## DESIGN EXCELLENCE PANEL MEETING

**PROPERTY:** 100 Mount Street, North Sydney

**DATE:** 29 June 2011 @ 4.00 pm in the Geddes Room

The applicant is proposing modifications to the consent under Section 75W of the Act and the Department will be determining the application. The application is likely to be lodged in approximately one month's time.

drawing  
**Comparison with Approved Scheme -  
Retail Level + Ground Floor**

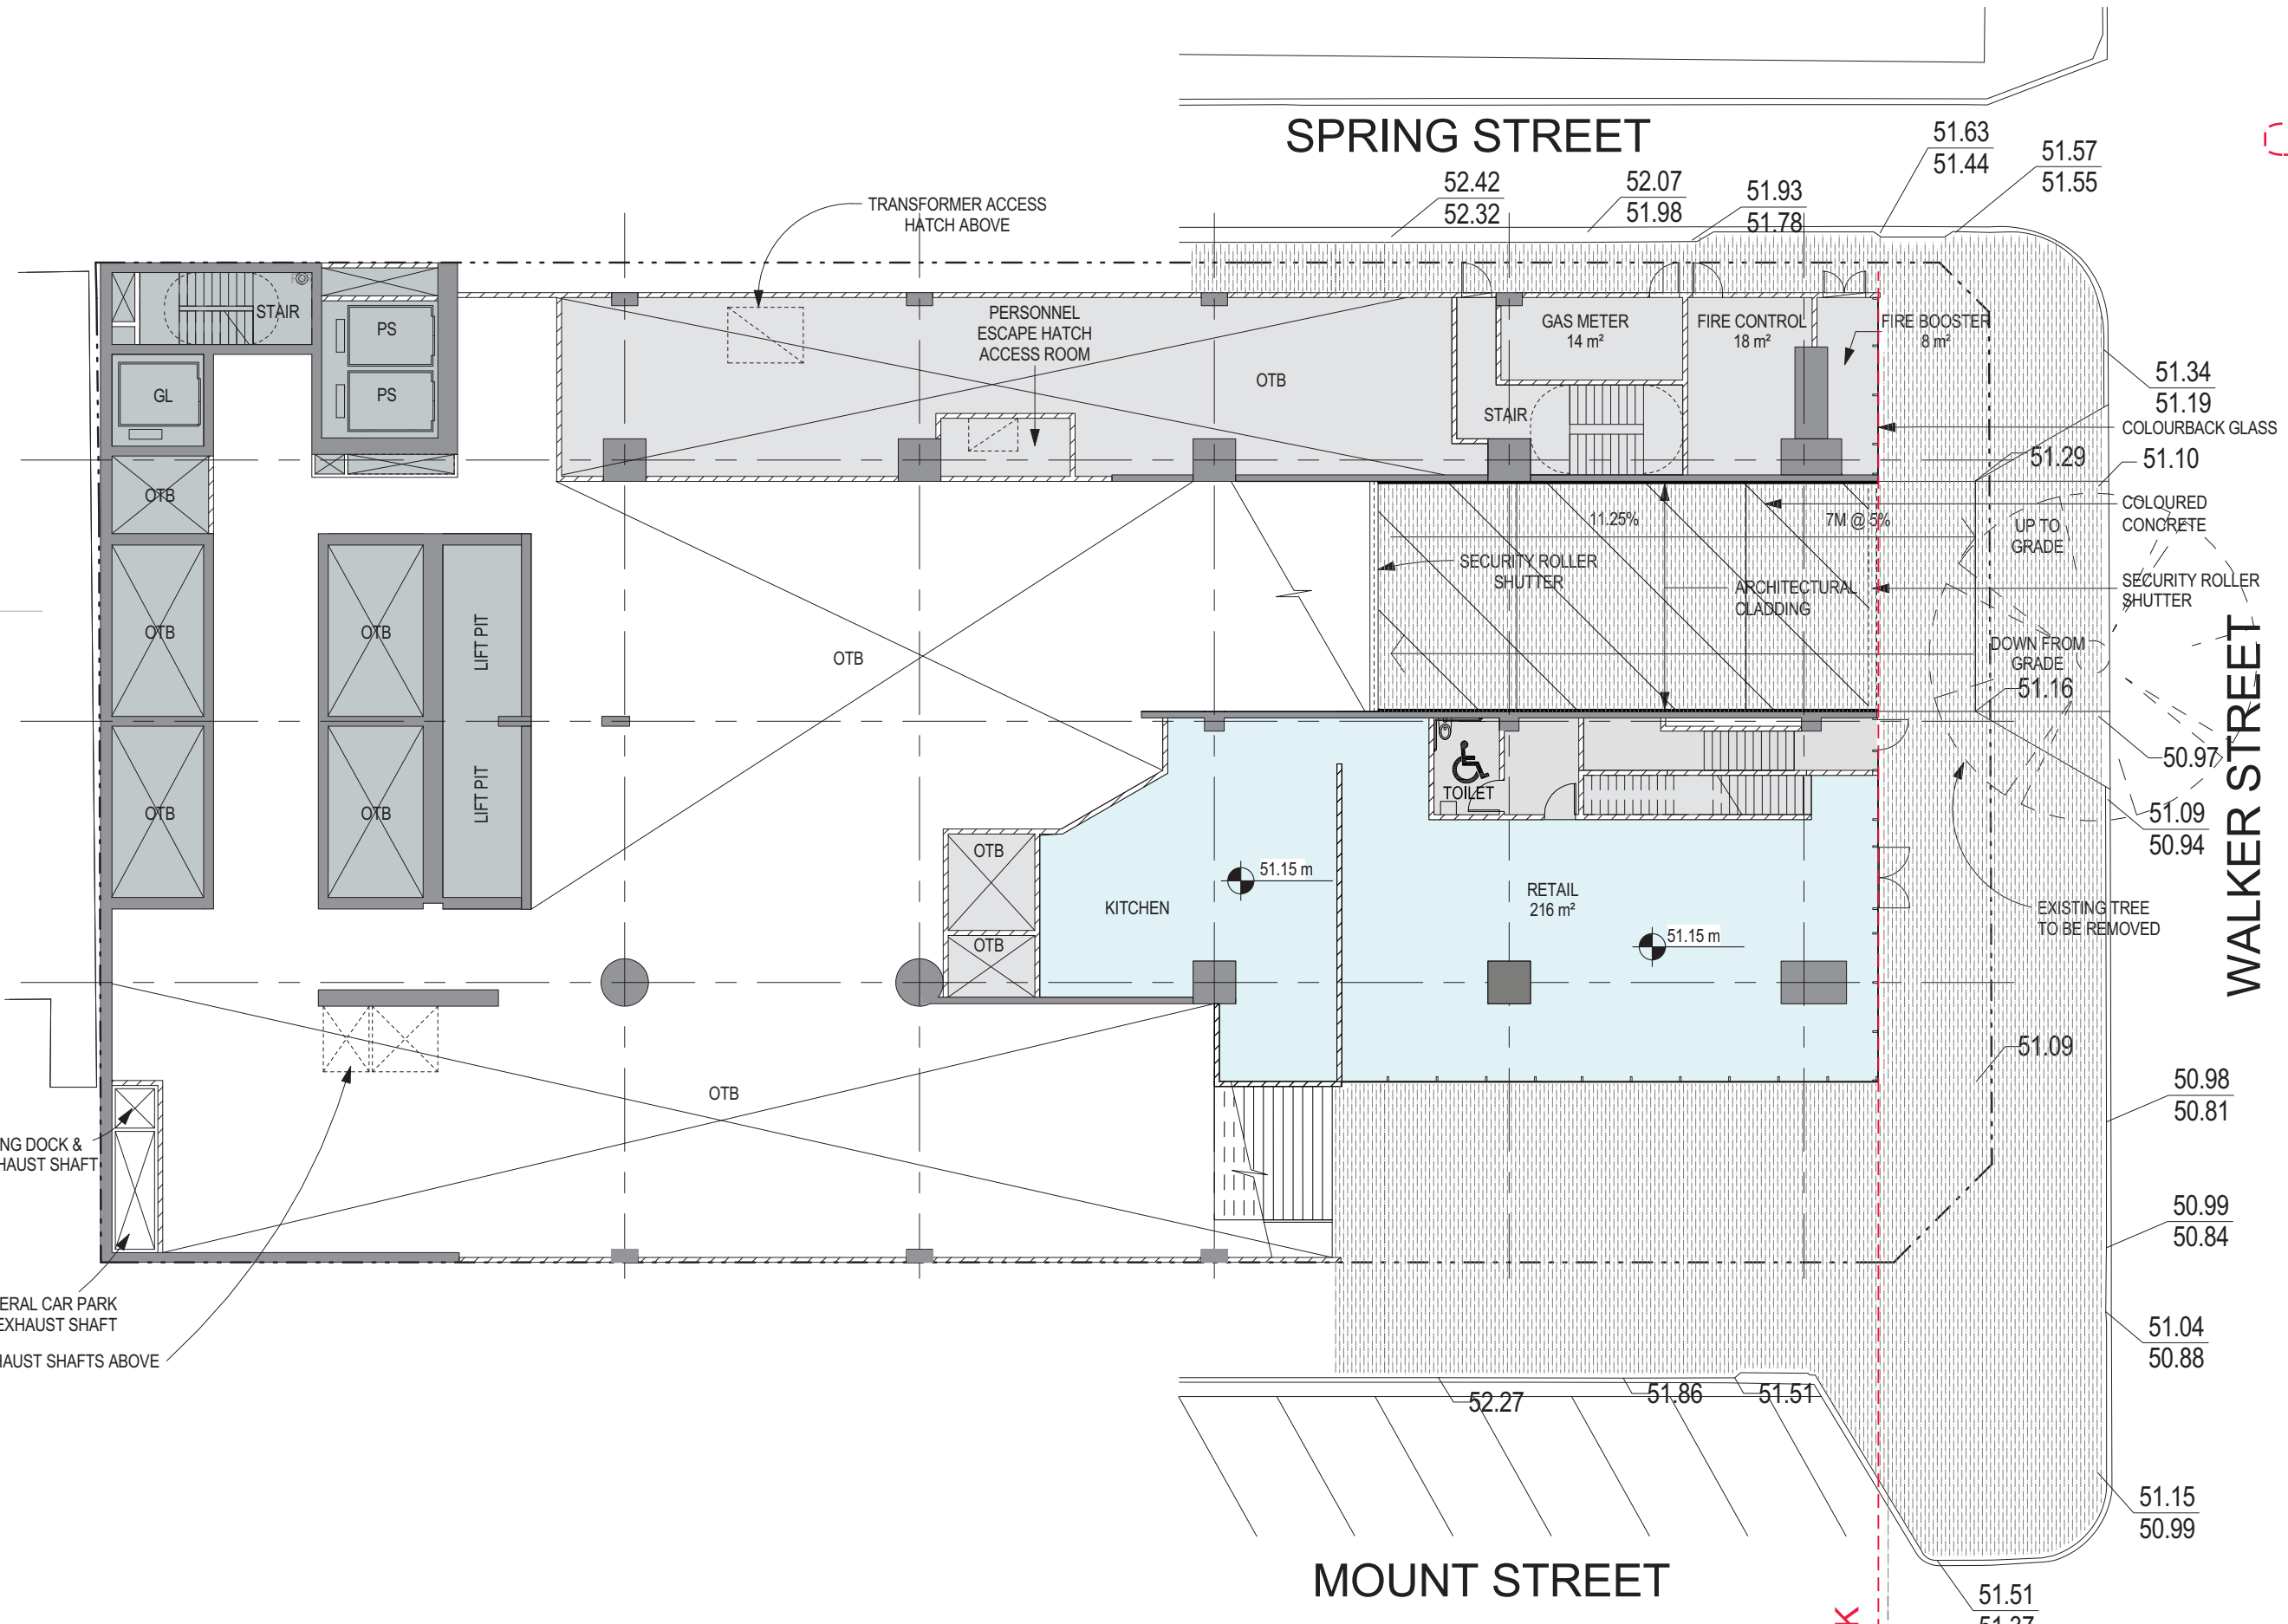
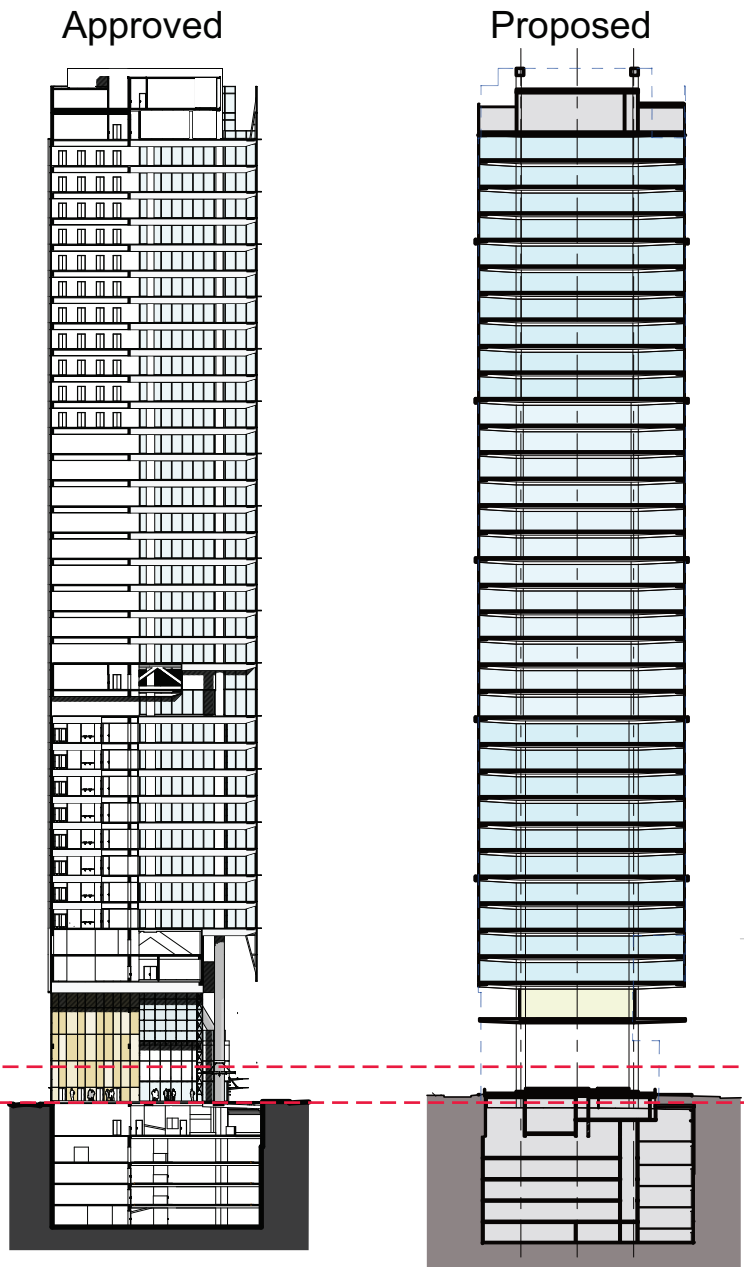
The Panel supported the relocation of the vehicle entrance to Walker Street providing that the balance of the Walker Street frontage is as active as possible. The Panel supported Spring Street becoming a shared zone.

The Panel supported the plaza option 02 for the treatment at the corner of Mount Street and the plaza above. The Panel suggested an awning over the Walker Street footpath in line with awnings to the north and the wall north of the carpark entrance being setback to widen the footpath into Spring Street. The plaza topography diagrams indicate that the detail resolution of the plaza and other proposed ground floor uses are not yet sufficiently developed with regards to their connection to the surrounding public domain. In particular the south east corner of the plaza area at the corner of Mount and Walker Streets. The lower level retail area could be enlarged and better relate to Mount Street if the stair between Mount Street and the plaza was either relocated or reconfigured. The area between the stair and the street edge also requires further consideration.

The Panel questioned the need for stairs to the south of the plaza. The Panel recommended that the through site link be kept as direct as possible and on the one level.

The Panel was concerned that the present street trees are shown to be removed, they presently play a very important role in creating an attractive and cohesive character in both streets, and have now reached semi-maturity. Their loss would be extremely unfortunate.
